A585 Windy Harbour to Skippool Improvement Scheme

TR010035

7.11 Environmental Statement Changes and Corrections Document

Version	Date	Status of Version
Rev 0	May 2019	Deadline 2 Submission
Rev 1	July 2019	Deadline 4 Submission

APPENDIX D – Updated Figure 11.1: Noise and Vibration – Noise Monitoring within the Study Area and Figure 11.4: Noise and Vibration – Noise Mitigation

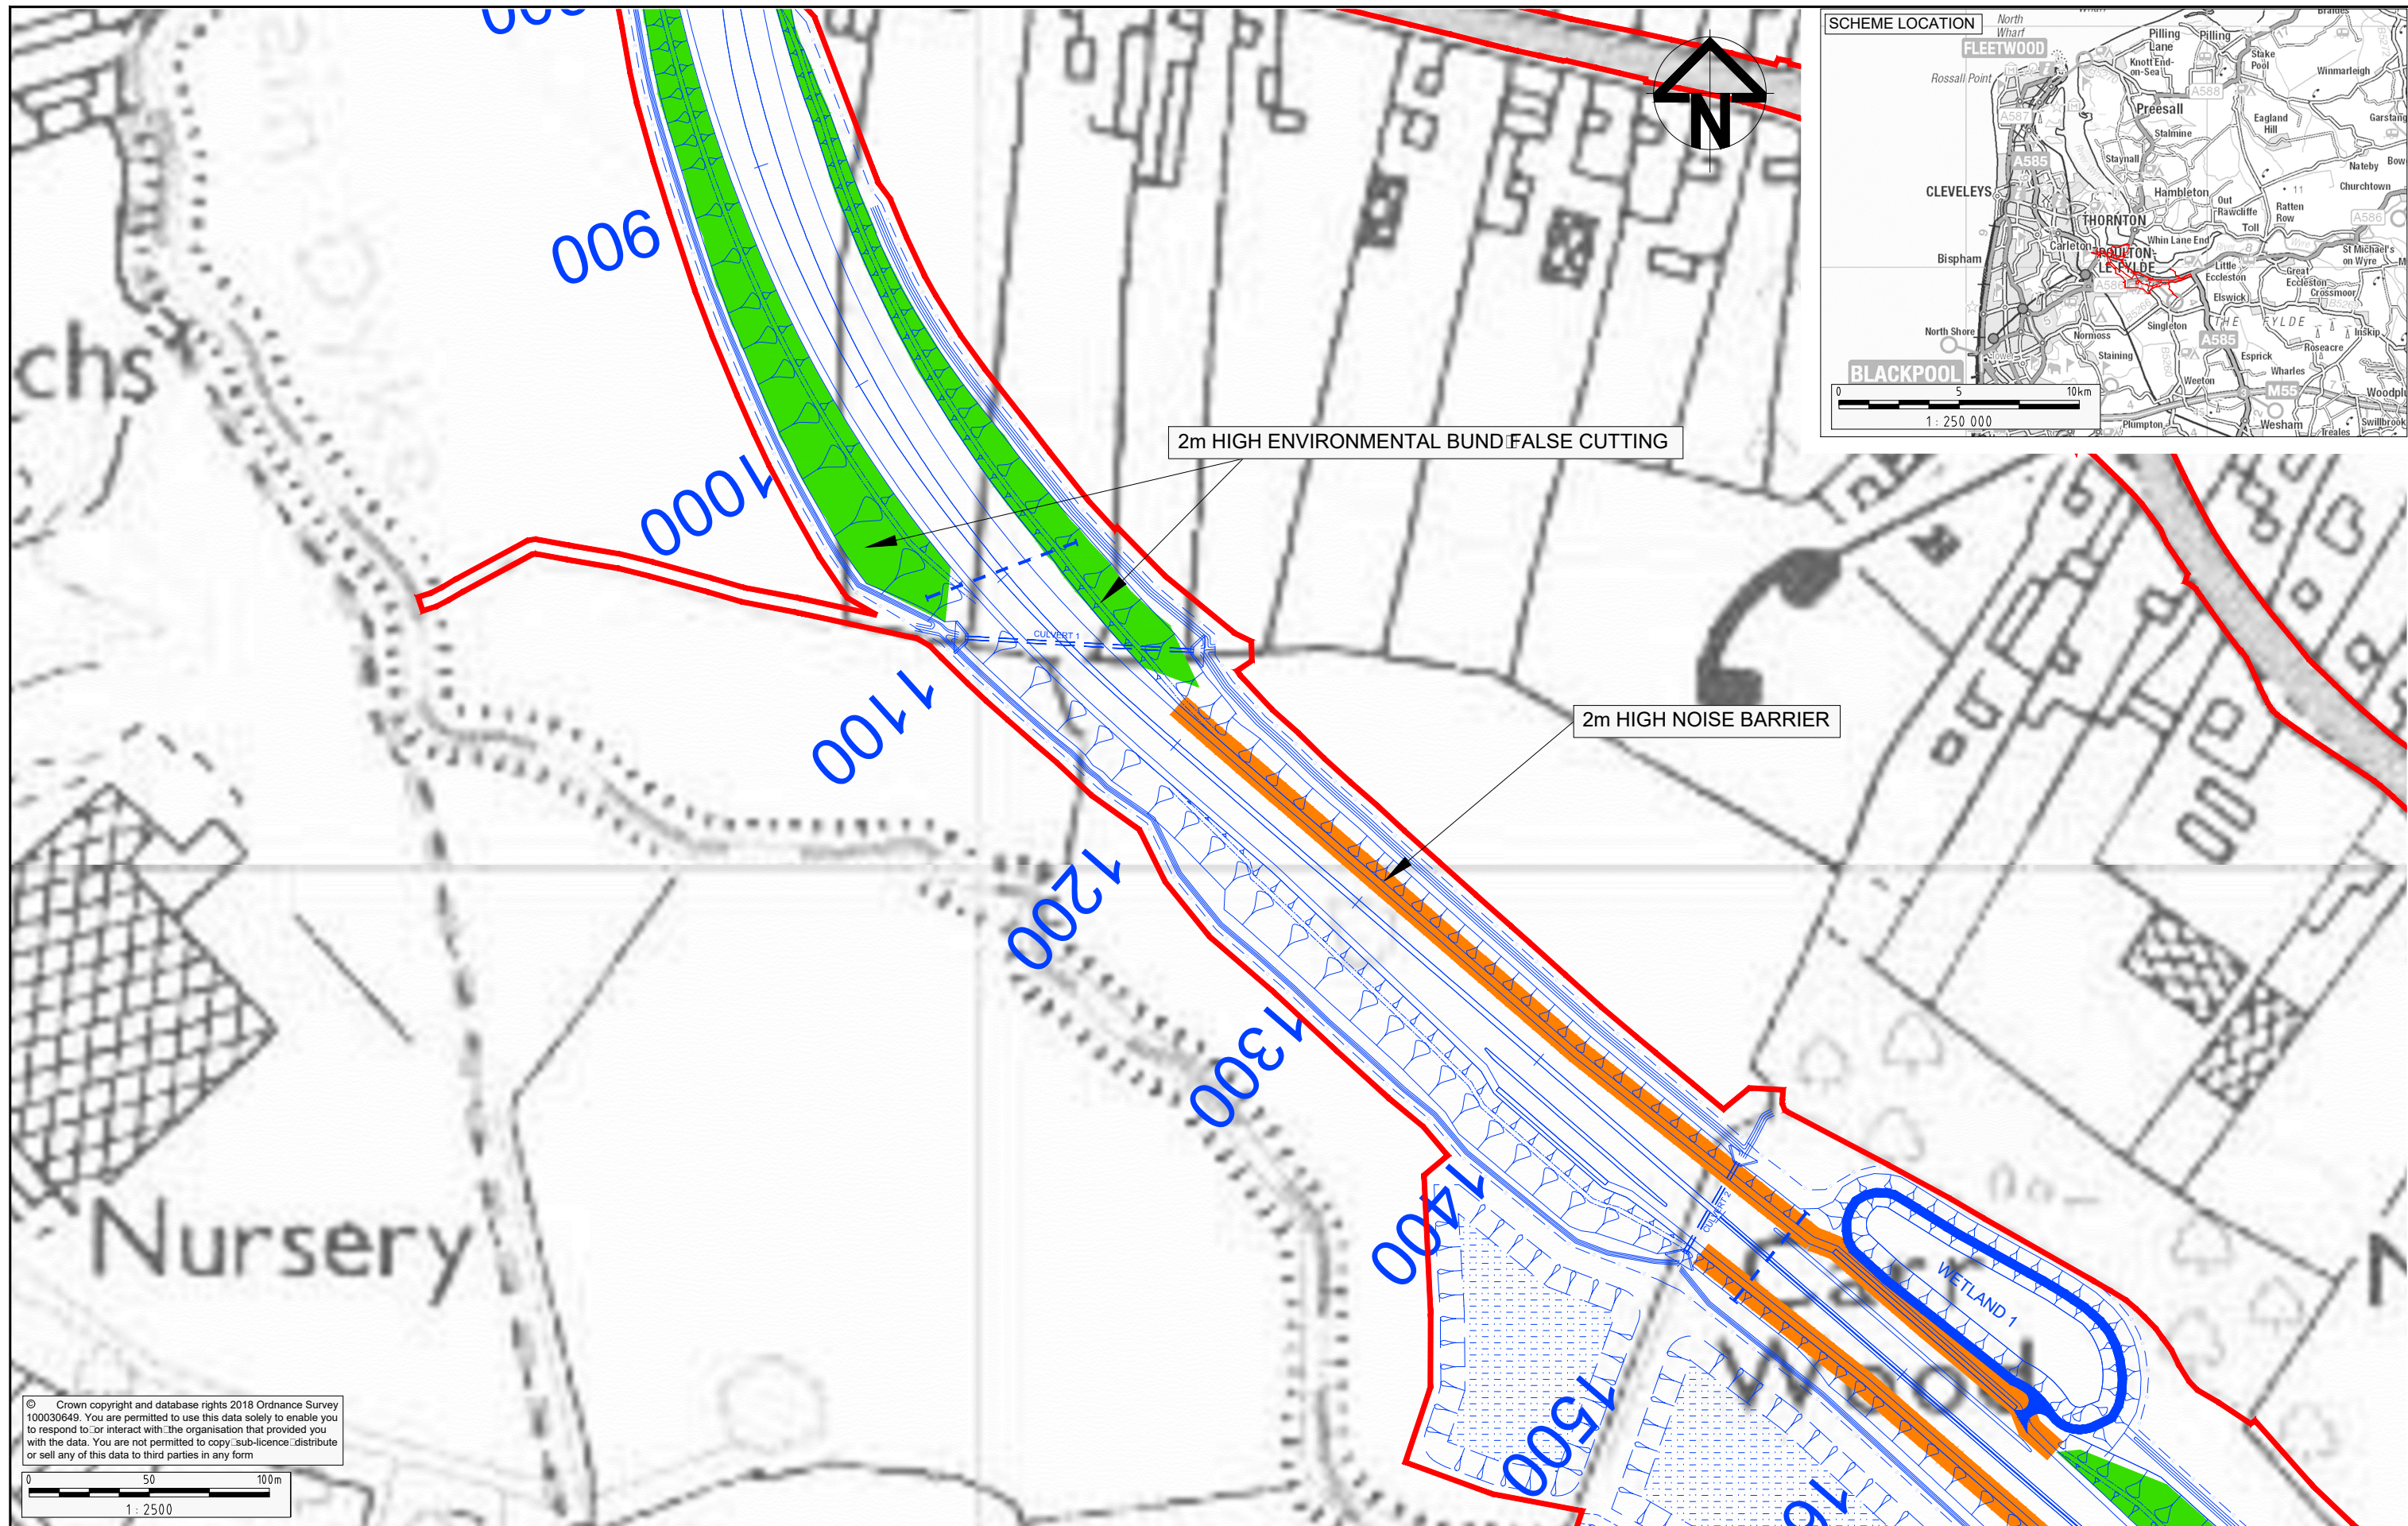
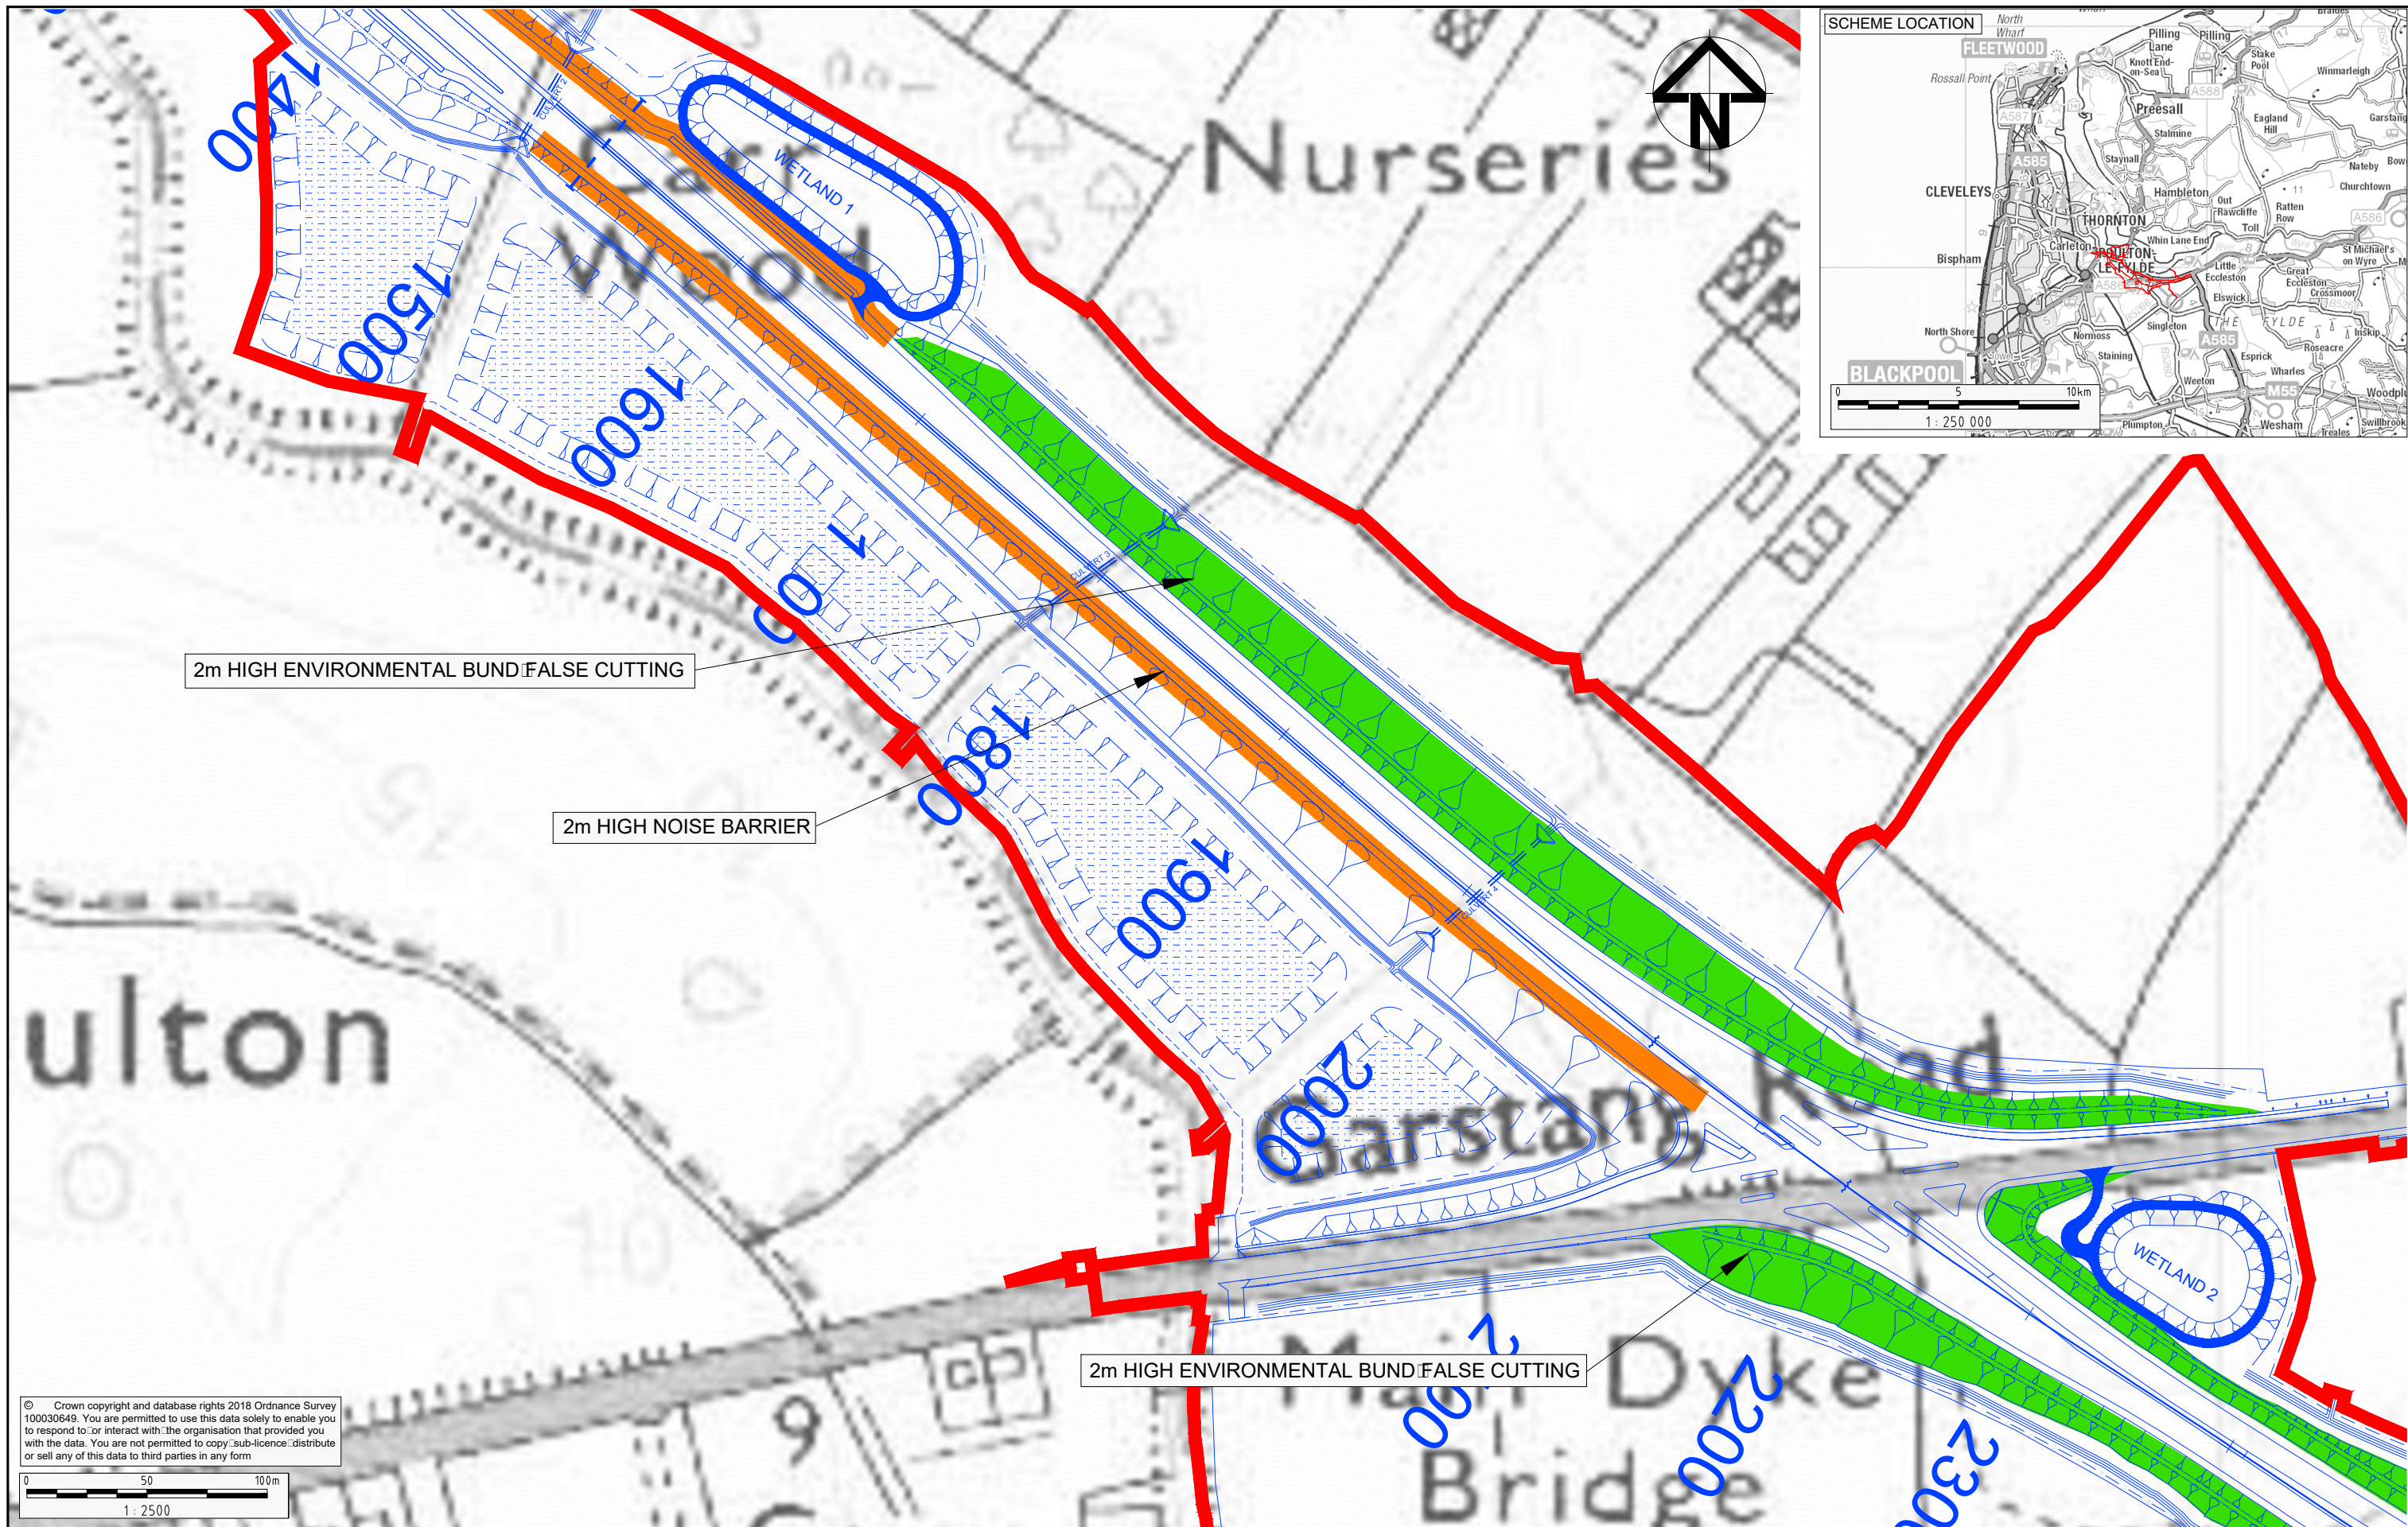
Document Reference Number	Document Name	Amendment Required	Reason
			TR010035/APP/7.10).
6.11	ES Chapter 11: Noise and Vibration	Update to Figure 11.4: Noise and Vibration – Noise Mitigation within the Study Area presented at Appendix D to show heights and locations of earth mounds and acoustic fencing at a larger scale.	Requested by the Inspector within the first round of written questions (document reference TR010035/APP/7.10).
